Our Ref: S06/0041
HQ09/0869

24 September 2009

RE: **Environmental Assessment – MP 05-0198**
Walmsley Road & Stott Street, Bilambil Heights

PLAN OF PROPOSED SUBDIVISION OF
LOT 1 DP 167380, LOT 1 DP 134787, LOT 2 DP 961928 AND
LOT 5 DP 1117326, WALMSLEYS ROAD AND
STOTT STREET, BILAMBIL HEIGHTS
CLIENT : WALMSLEY AND DICKINSON

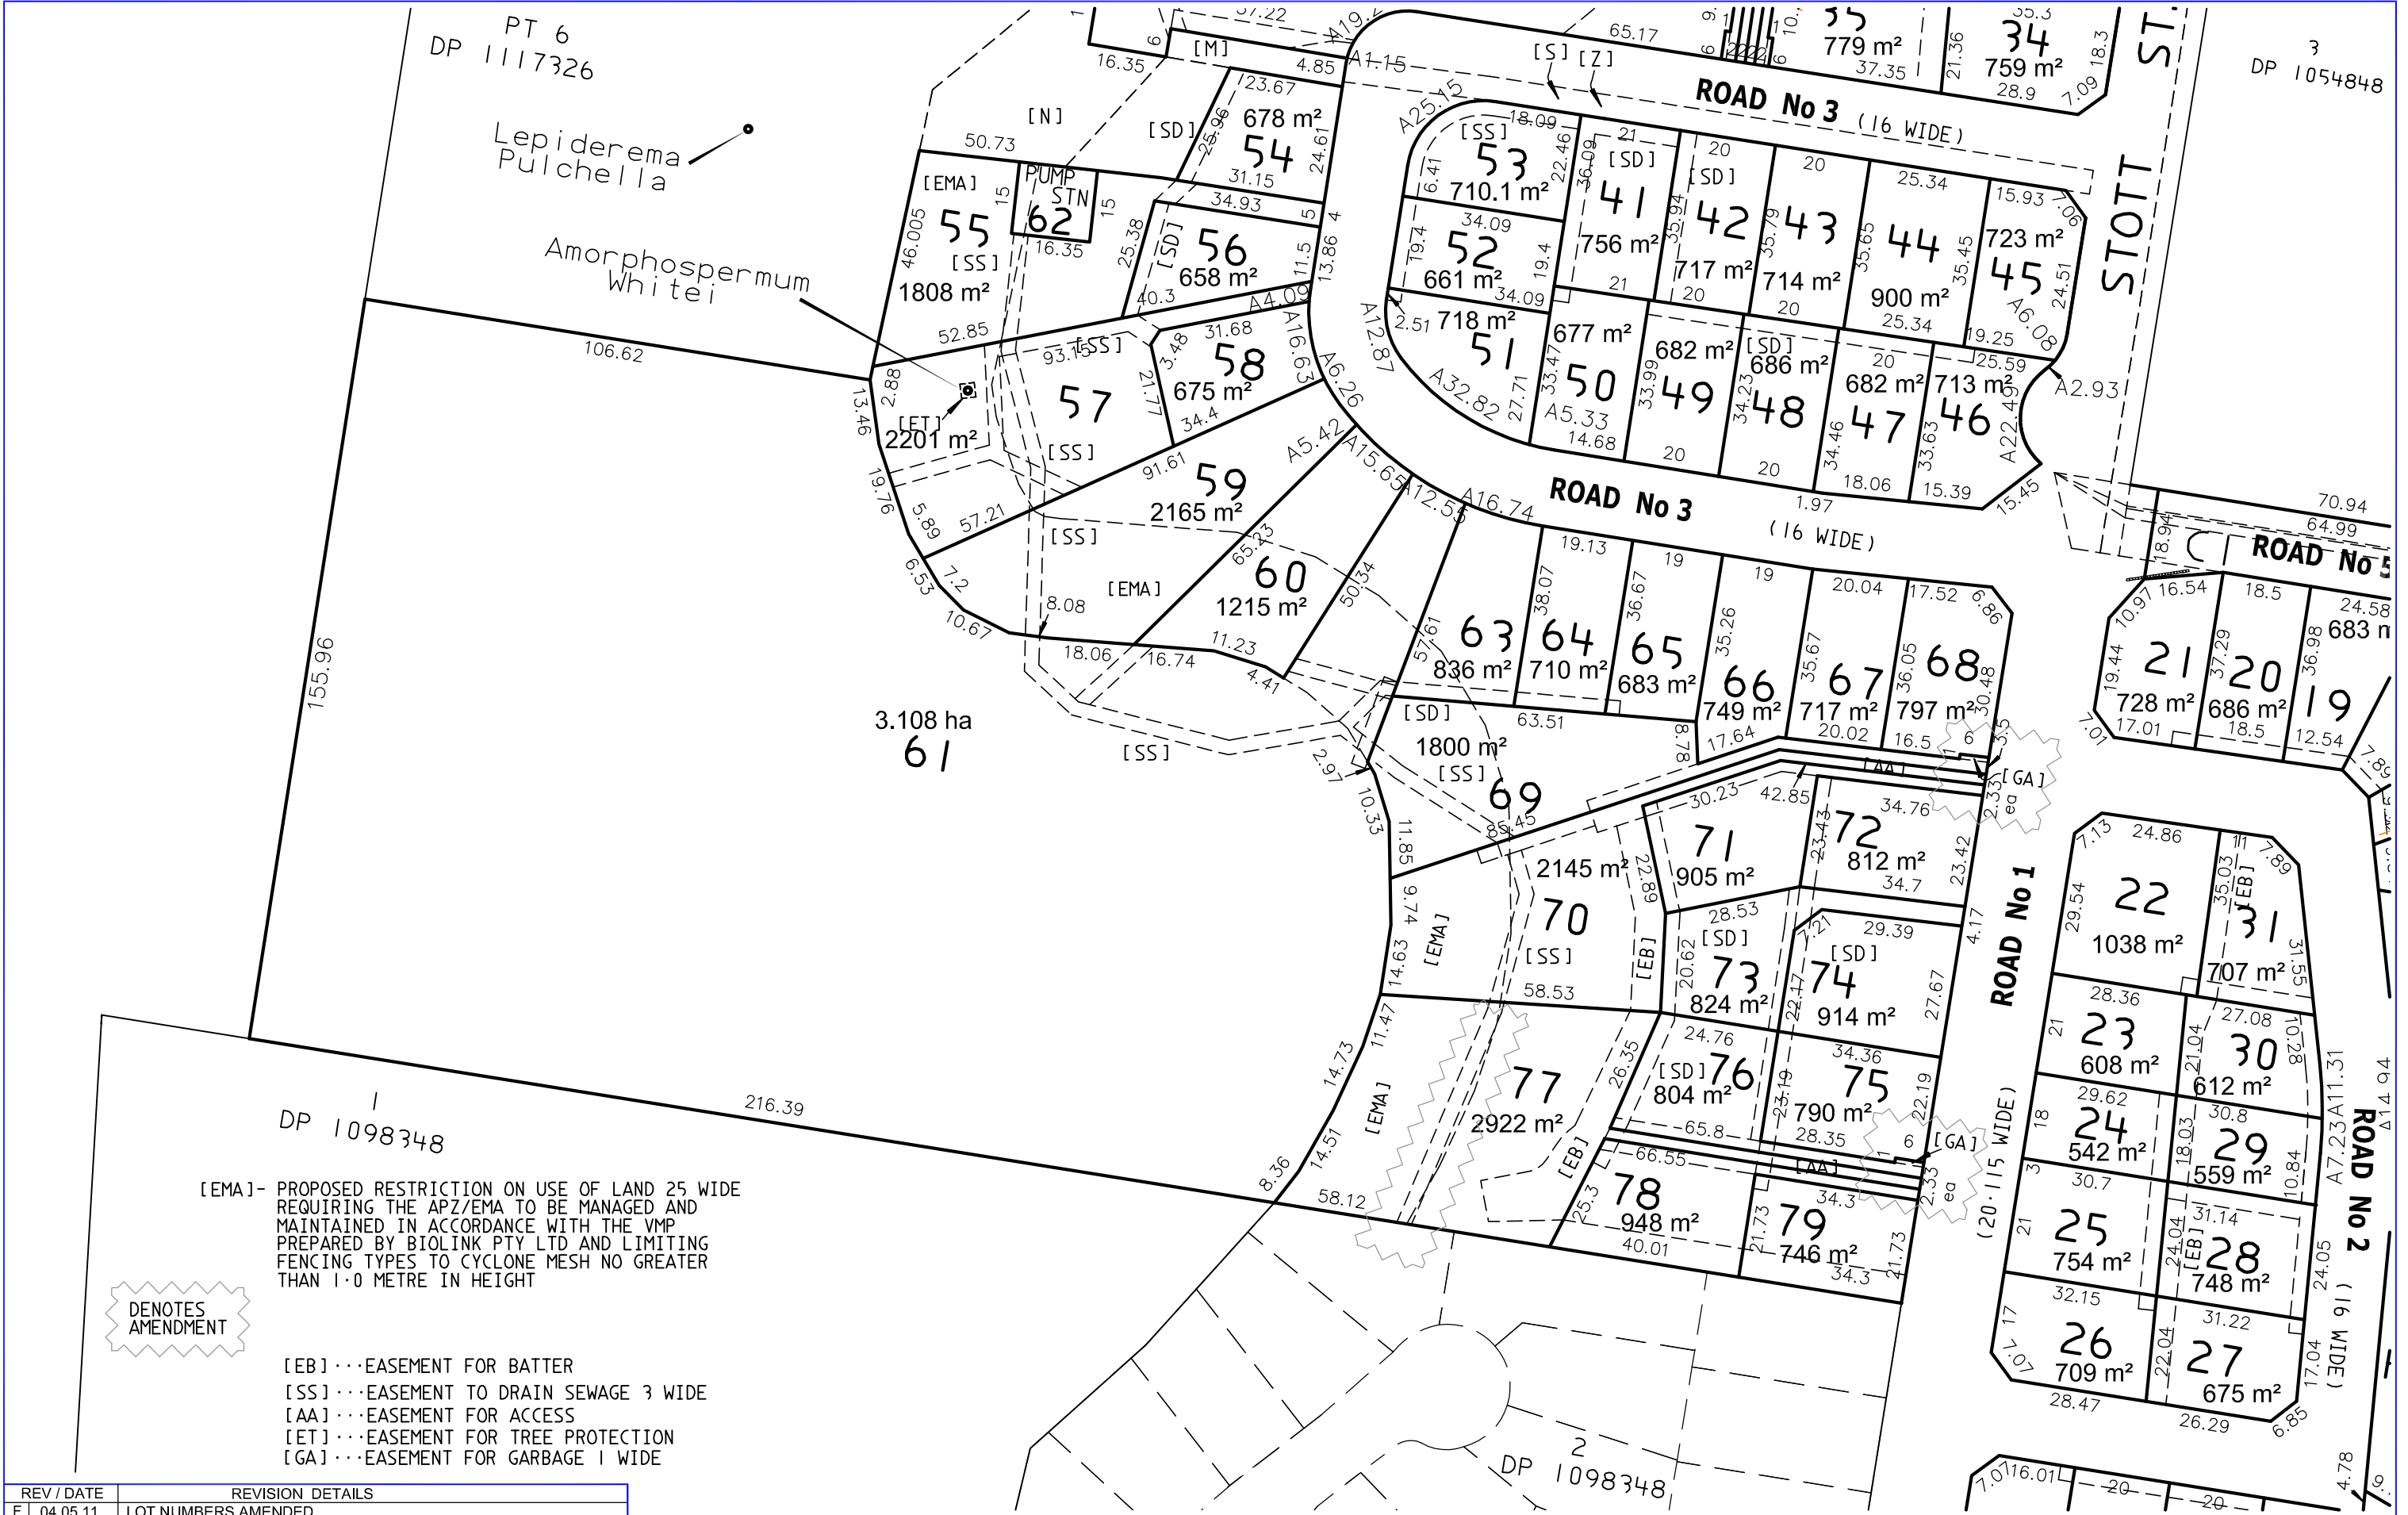
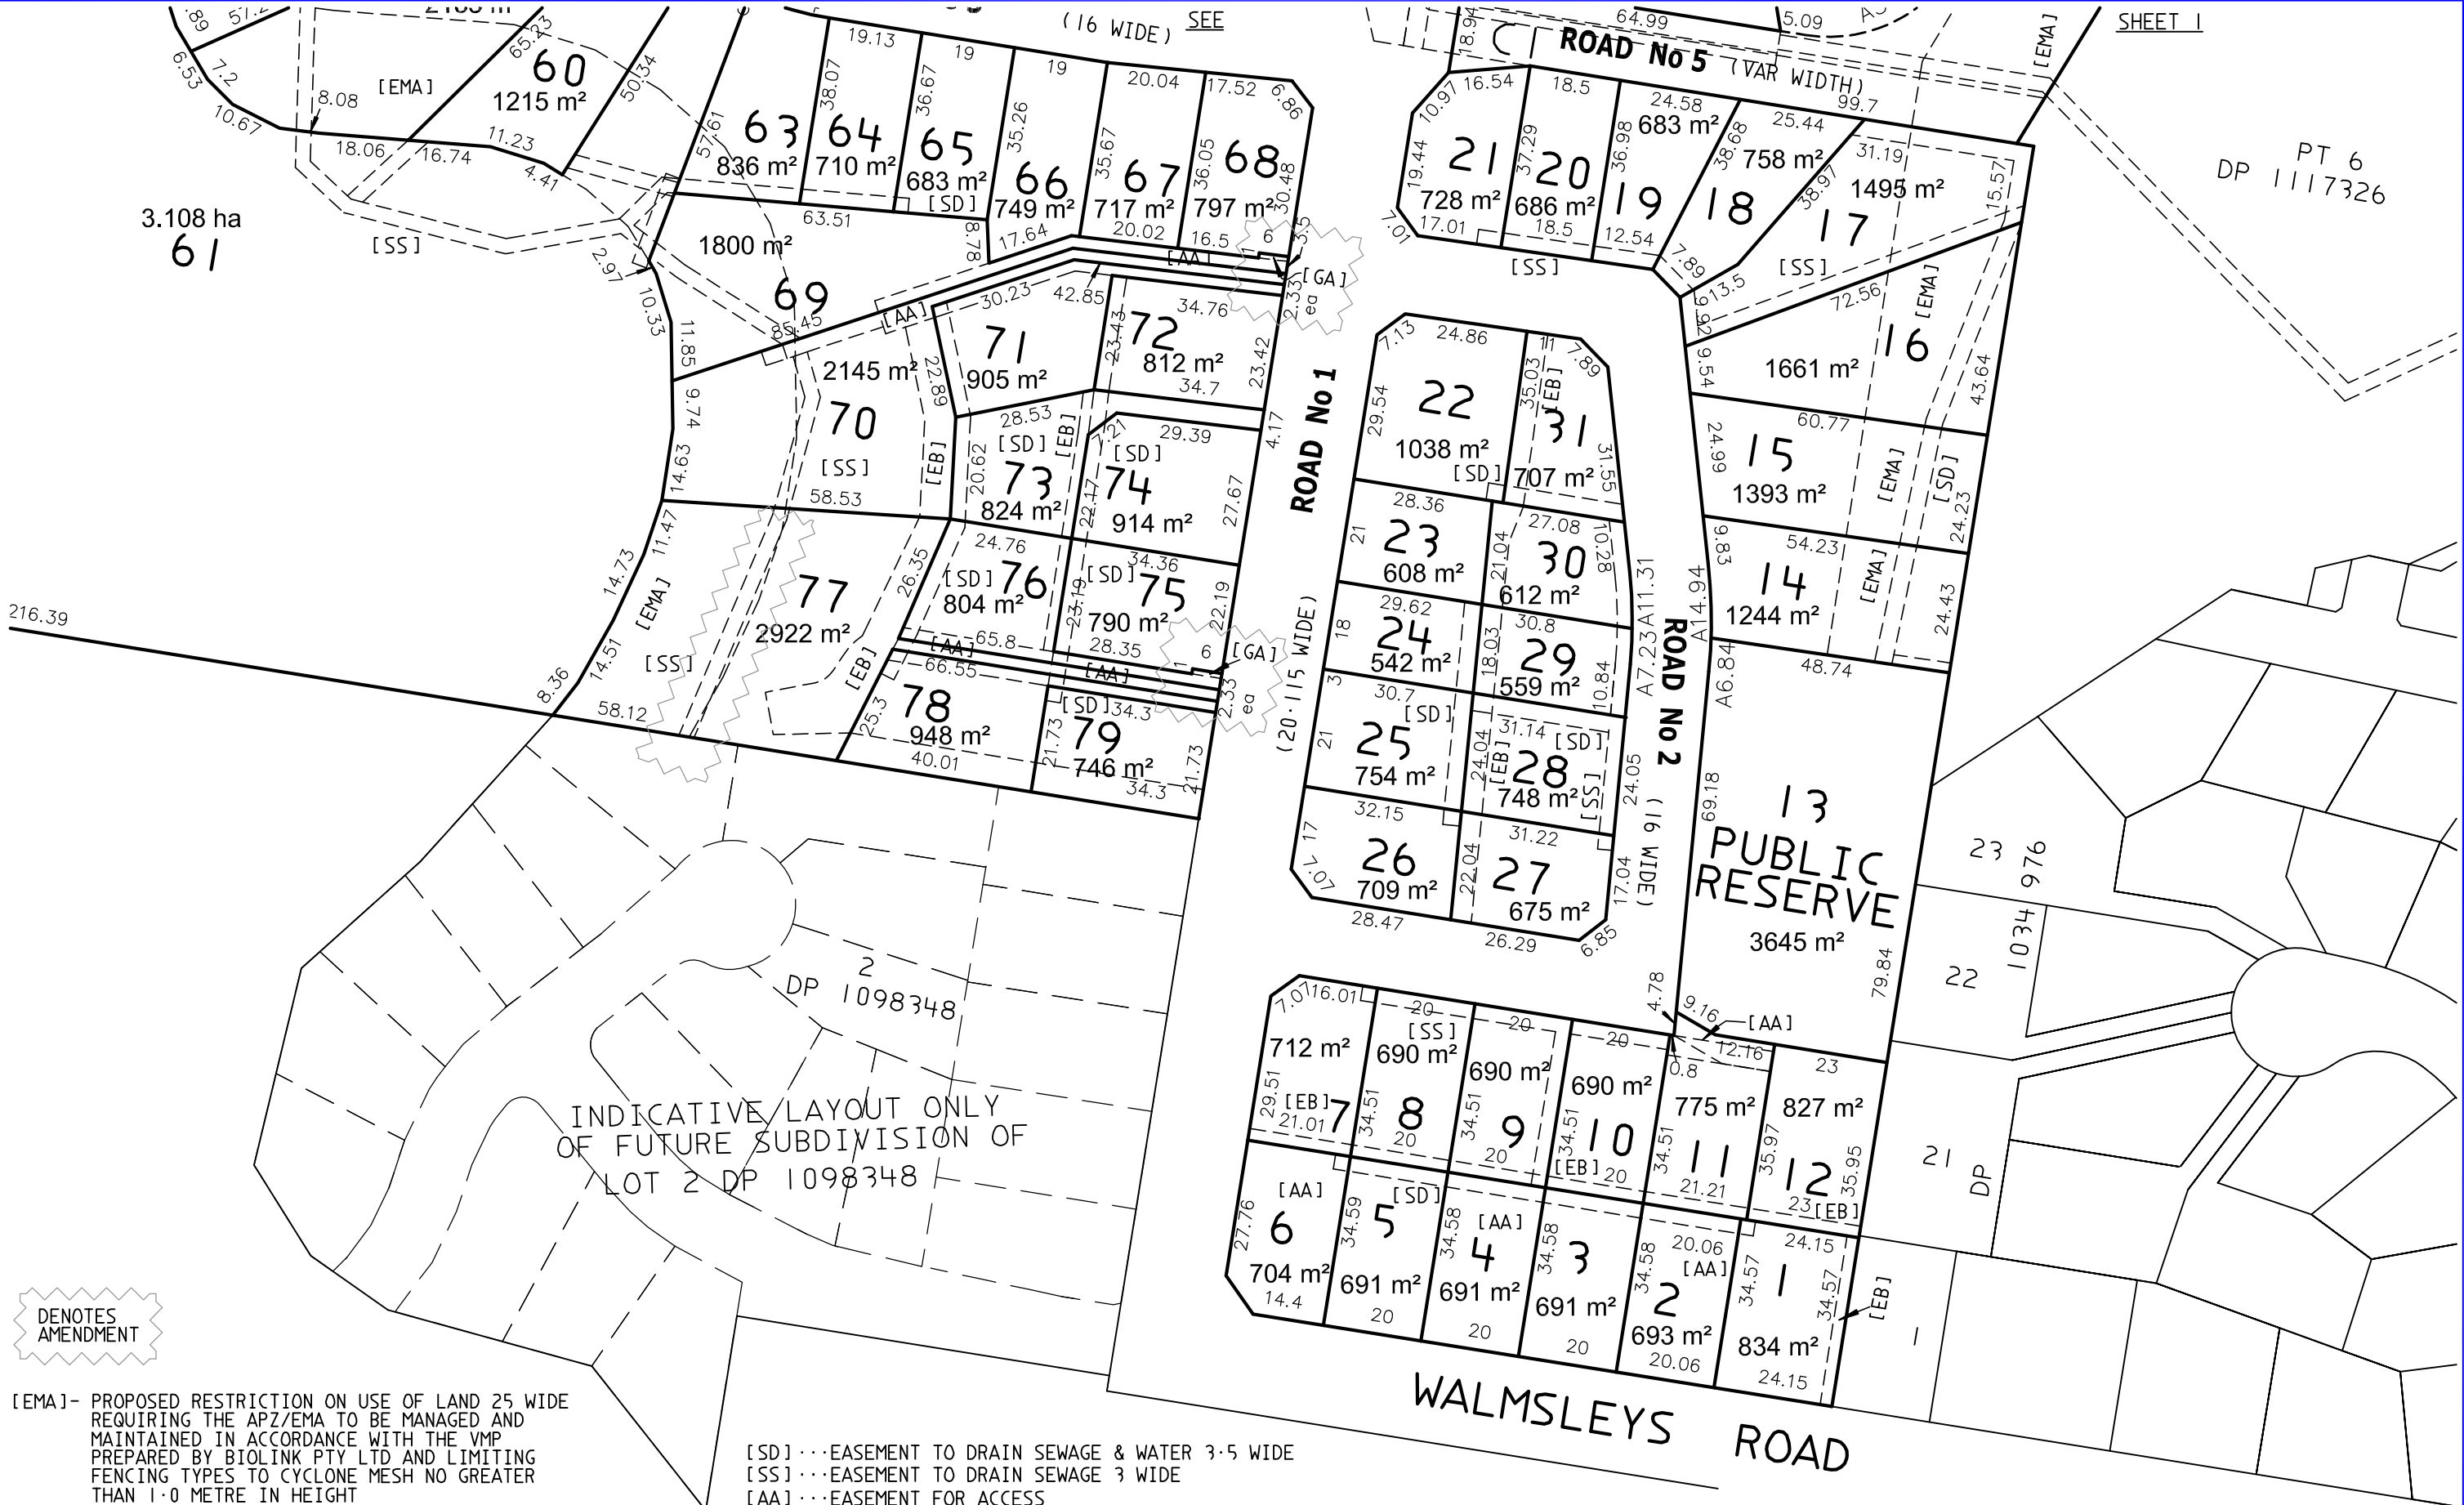
1. At the commencement of subdivision works and in perpetuity the entire site shall be managed as an APZ as outlined within Appendices 2 & 5 of *Planning for Bush Fire Protection 2006* and the NSW Rural Fire Service's document *Standards for asset protection zones*.
2. The proposed 25 metre APZ to the west of proposed Lot 56 lies outside the boundary of the property and is required to be protected and maintained in perpetuity. The APZ shall be managed as outlined within Appendices 2 & 5 of *Planning for Bush Fire Protection 2006* and the NSW Rural Fire Service's document *Standards for asset protection zones*.

For the proposed Lots 38, 39, 40, 41, 42, 57, 59, 60 & 61, the thinning of Camphor Laurel trees only within the 25 metre recommended APZ may not be sufficient to meet the requirements as outlined within Appendices 2 & 5 of *Planning for Bush Fire Protection 2006* and the NSW Rural Fire Service's document *Standards for asset protection zones*.
